**22/01682/F**

**Land North Of Manor Farm Noke**

**Development of a ground mounted solar farm incorporating the installation of solar PV panels, associated infrastructure and access, as well as landscape planting and designated ecological enhancement areas.**

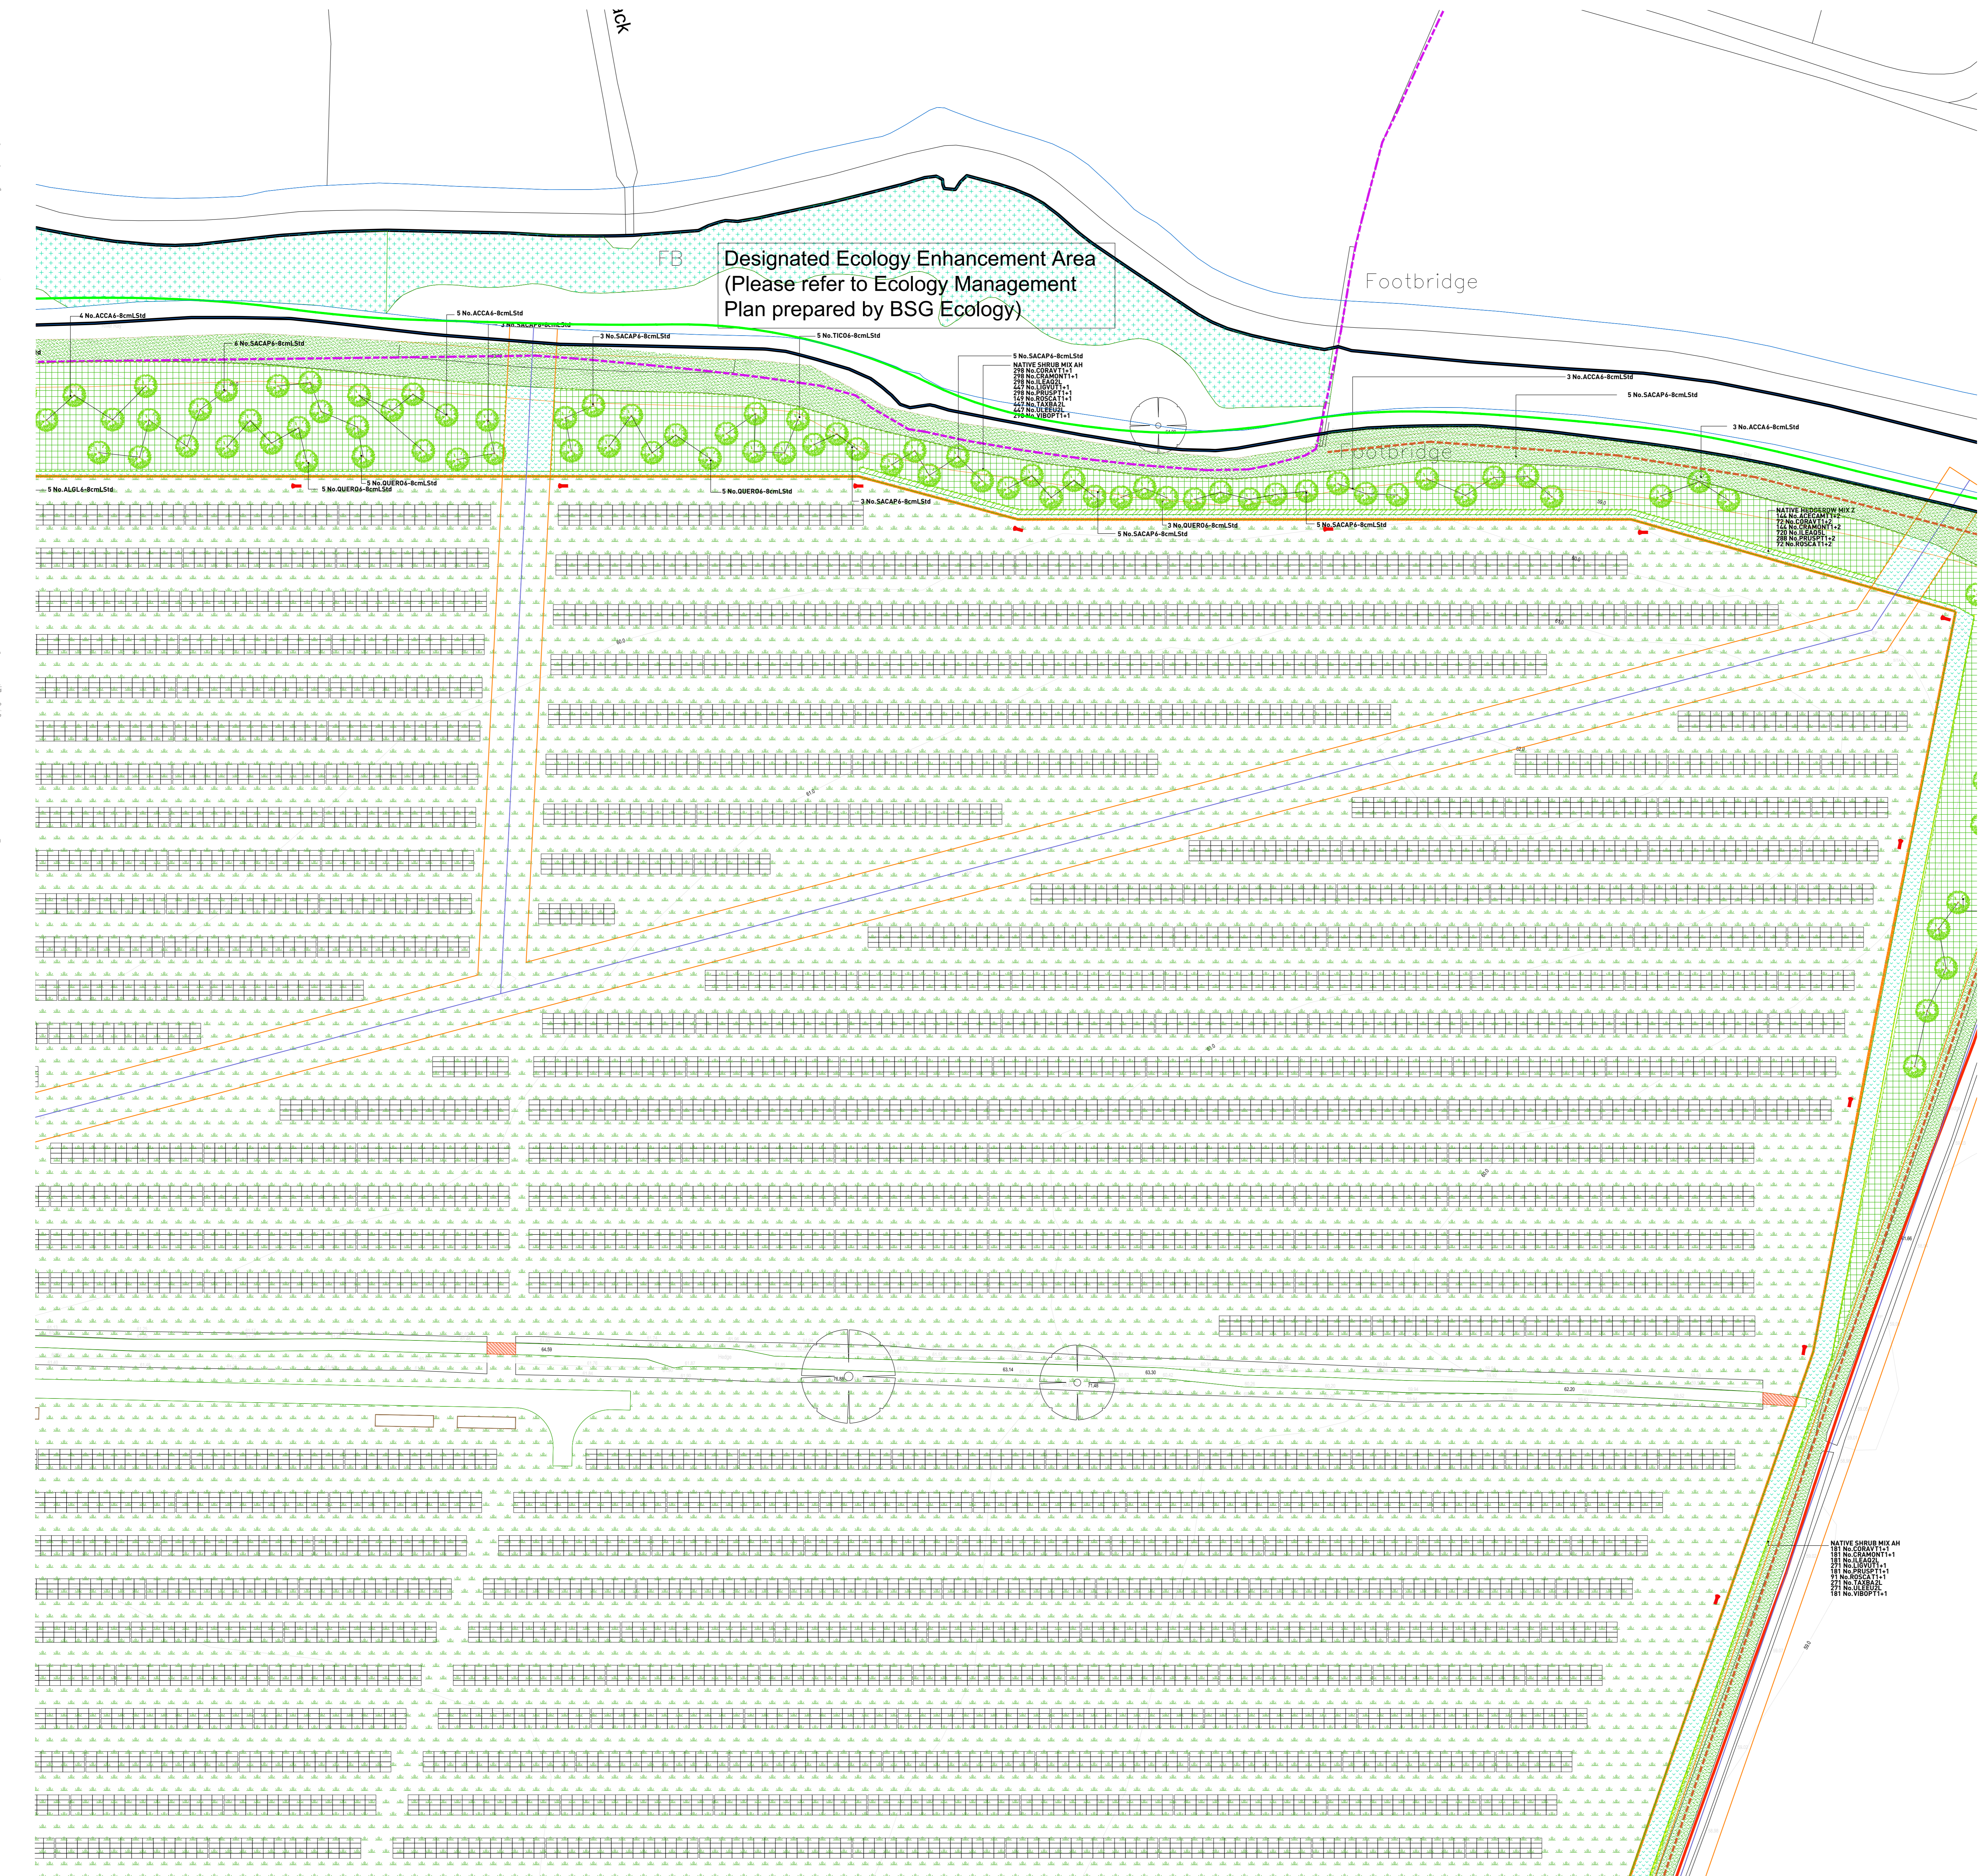
- The removal of the proposal for tall security fencing. The application includes plans for security fencing 2.1m in height. This is likely to present a significant collision risk to low-flying birds, that would be of particularly high risk in the proposed location bearing in mind the proximity to Otmoor and the fact that birds would be taking off or landing on Otmoor with flight paths that may put some of them at risk from the security fencing. The fencing would also have significant impacts on the movement of some mammal species. We therefore consider that in this location no security fencing should be used.

Title:
PV Module Elevation
and Cross Section

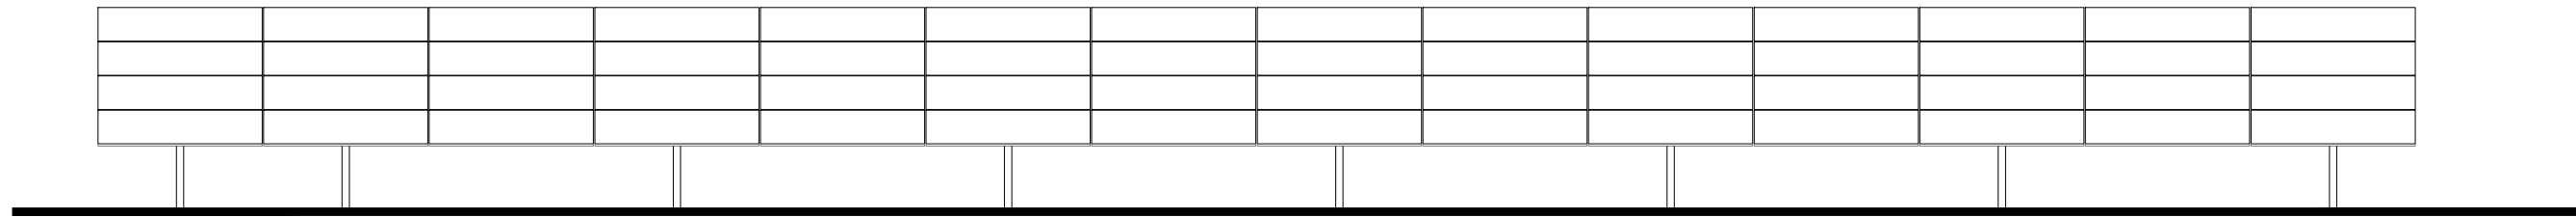
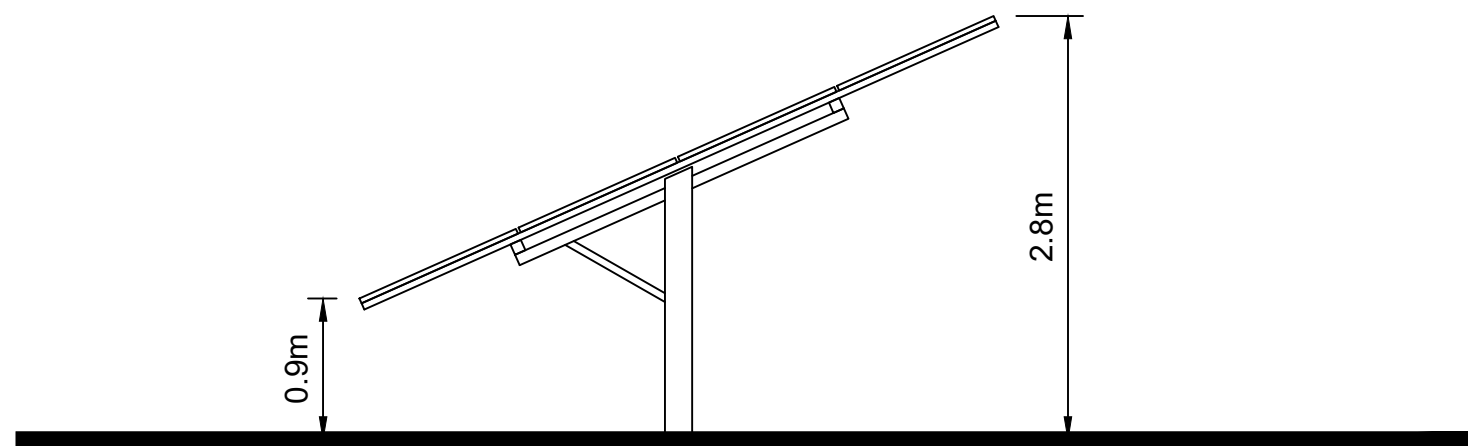
- Measures to reduce the likelihood of some of the issues referred to in the first section of this response are provided, such as 1) reducing polarised light from the solar panels, and 2) reducing the density of the solar panels, by widening the corridors between the panels, so as to reduce any resemblance to a lake, and the intensity of the polarised light issues. Some measures are set out in the BGS review (*Potential ecological impacts of ground-mounted photovoltaic solar panels - An introduction and literature review – 2019*). There are coating measures available to reduce polarised light from panels, and the affixing of white grid patterns on each panel to break up the reflections from panels to reduce the chance of attraction to
